Chief, Dam Safety Branch

Subject: Re: Retention Area Proposed in El Paso County

**MAJOR BASIN /  
 HISTORIC DRAINAGE PLAN**

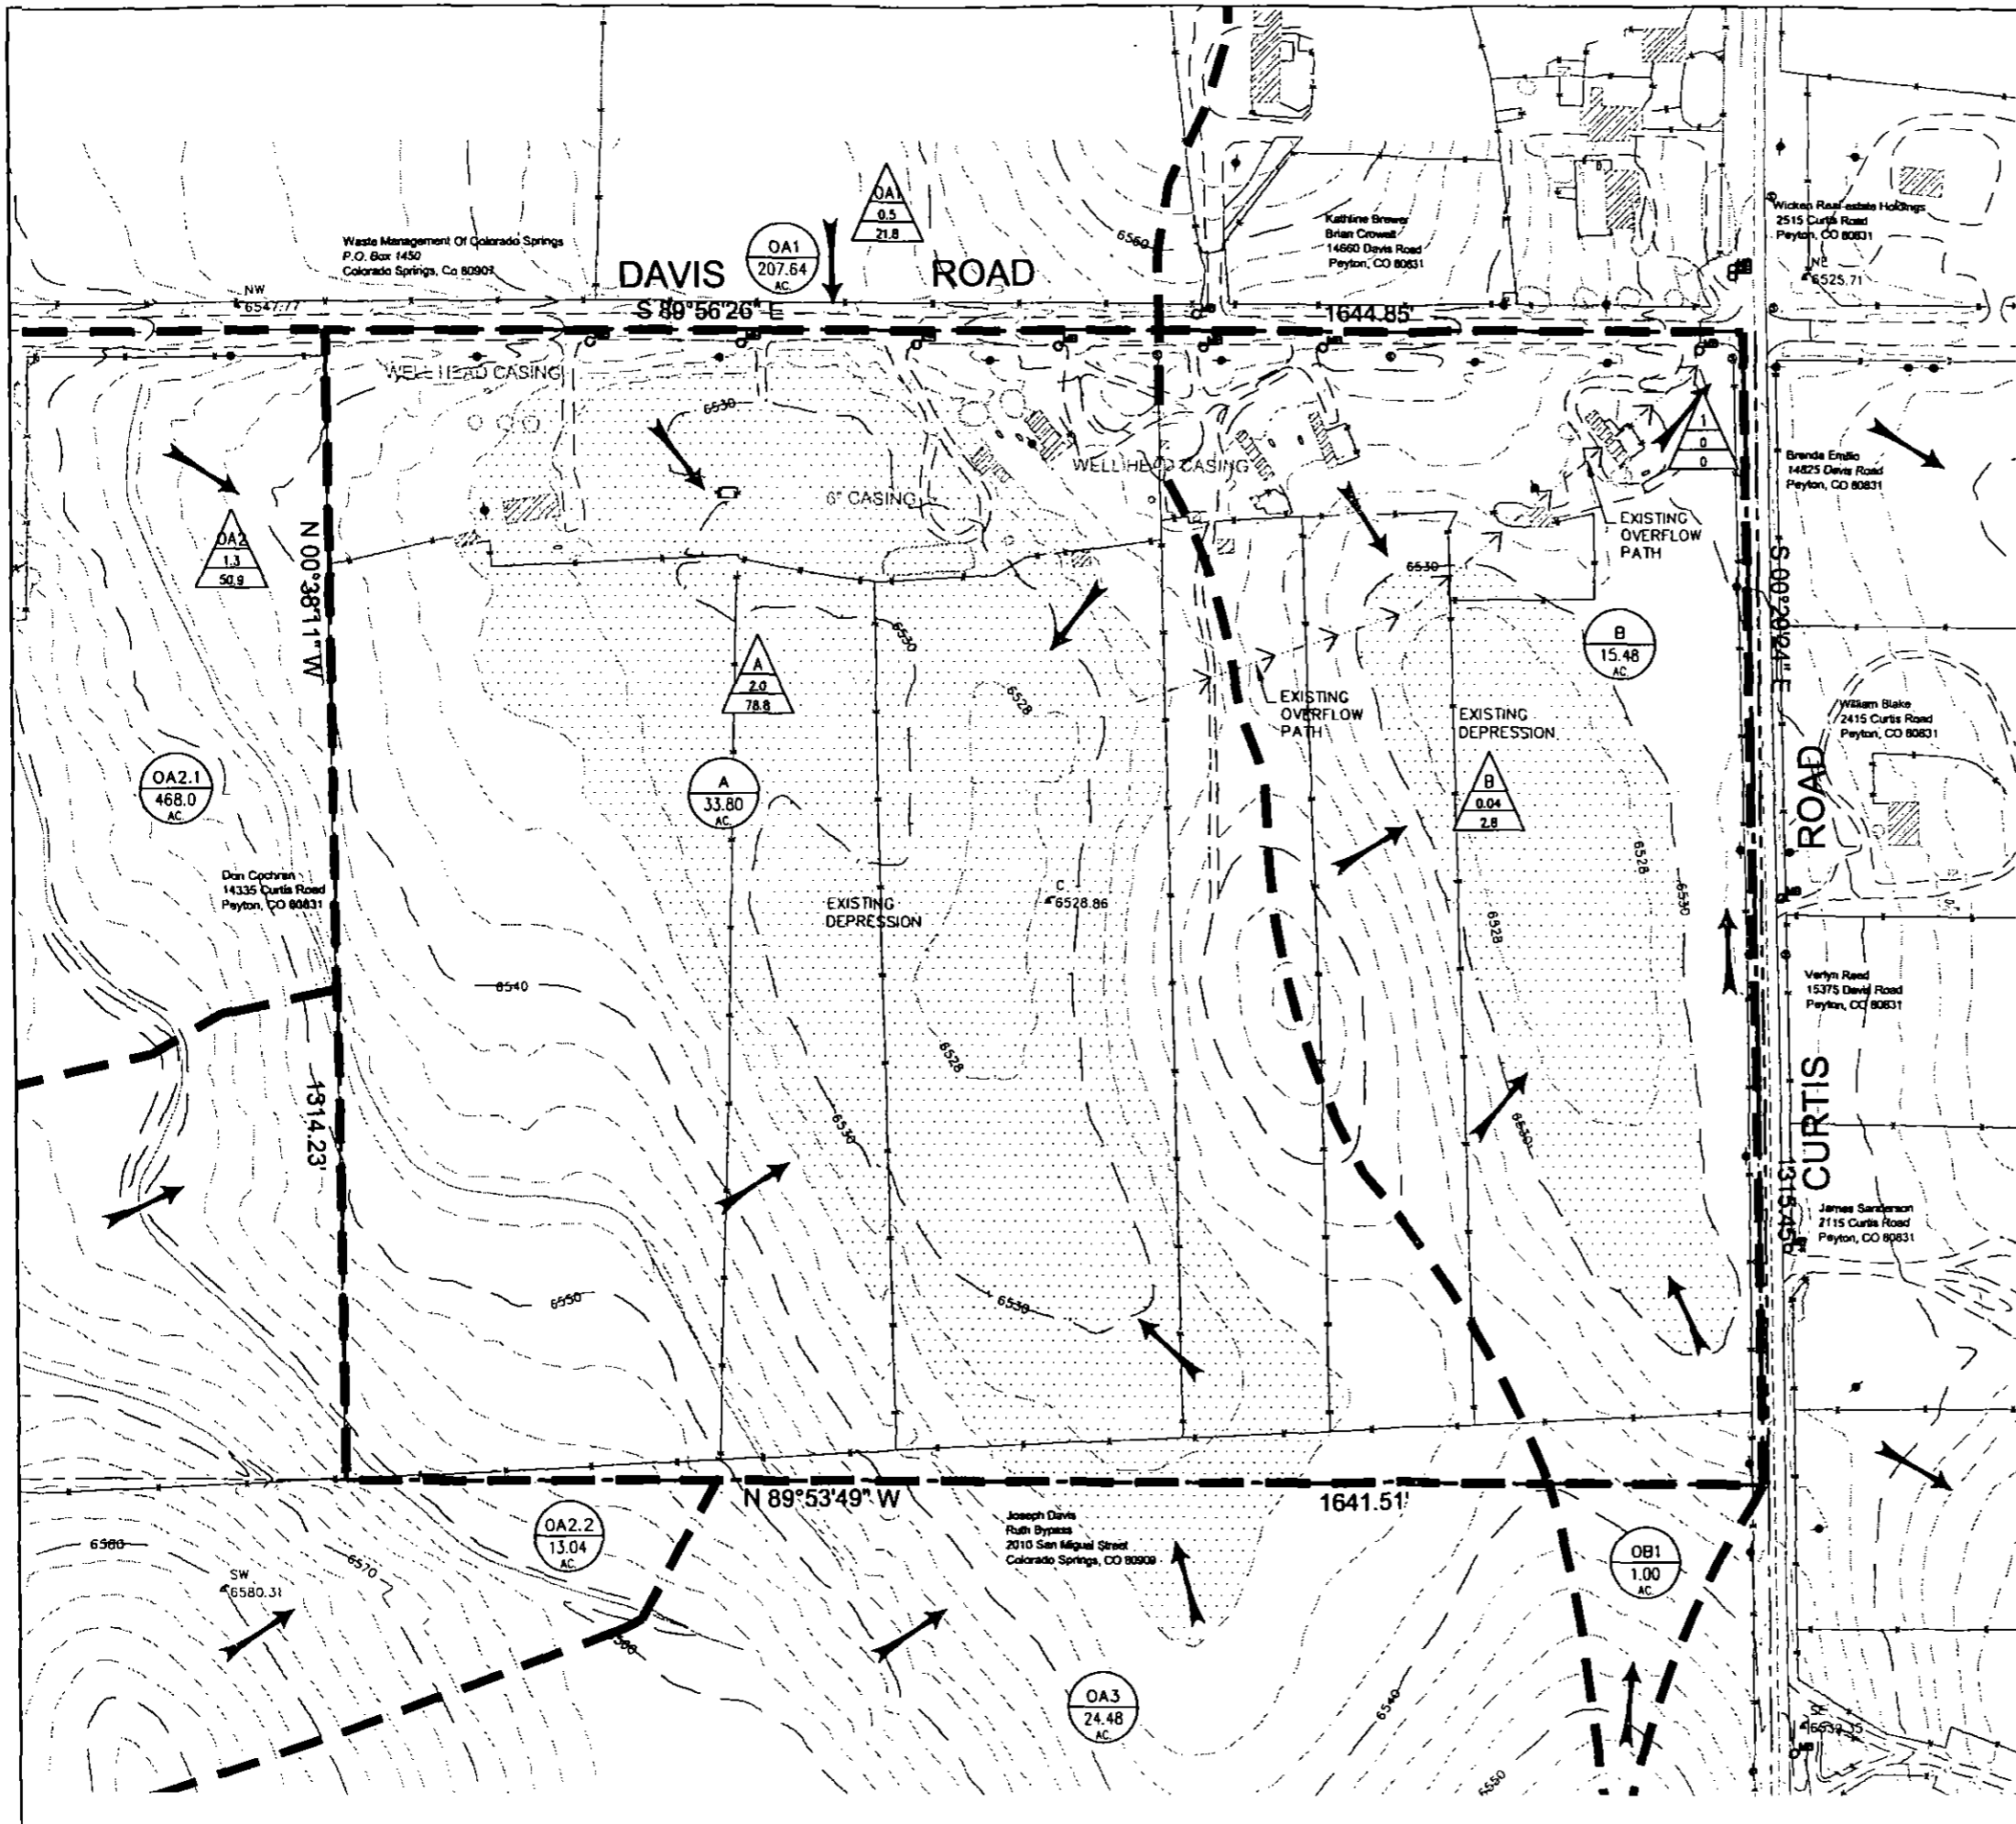
If, as design engineer, you are telling me that there will be no constructed earthen berm at ANY elevation above the existing natural grade to cause temporary or permanent detention of water that builds up any head/pool of water, then it is not a dam. I do not consider a natural depression (if that is what it will remain as) with a natural overflow point to be a dam that create enough buildup of water with potential energy to fail a constructed structure and cause downstream damage.

I've attached the historic drainage basin exhibit from the approved drainage report above. It shows two existing sub-basins on the site, each characterized by an existing depression (the hatched areas). Overflows from the existing depressions within the site (if they ever occurred) would drain northeast towards the intersection of Curtis and Davis roads. The developed runoff will follow the historic paths.

We currently have about 92 acre-feet of storage volume in Retention Area A between the 6528 and 6536 contours. Overflows from this retention area would (if they ever occurred) drain to Retention Area B which has another 7 acre-feet of storage volume between the 6528 and 6530 contours. Overflows from Retention Area B (if they ever occurred) would drain towards the intersection of Curtis and Davis roads where we plan to install a culvert. No 100-year flows would reach this point because of the substantial existing retention area in either the existing or proposed conditions so this culvert is only designed to convey flows beyond the 100-year flows.

I guess I need better understanding then. A quick look about spillway elevations, drainage retention areas, volumes of 2.8 AF, etc. gives me the initial impression that some

kind of earthwork will cause some ponding of water whether intended as temporary detention or permanent retention. I guess I need further clarification from you then to firm up the understanding. I don't have the full topo, is it all below grade 2.8 af of retention?
